July 17, 2018

Site: ABQ North Storage

Re: Drainage Ordinance (14-5-2-1) Violations for Erosion and Sediment Control

Drawing file: ESC / 24x36 Stamped ABQ NORTH STORAGE ESC MAP.pdf

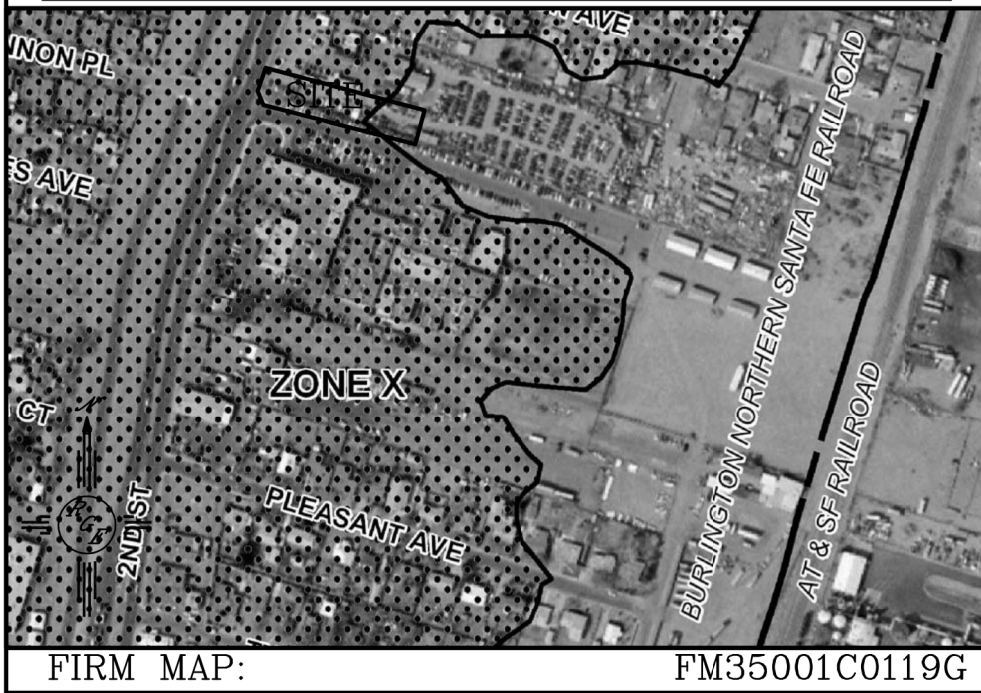
1. Earth disturbance has begun at the site and stormwater controls have not been implemented.

No BMP on southern edge and new stockpiles.

Required Mitigation:

1. Implement stormwater controls.
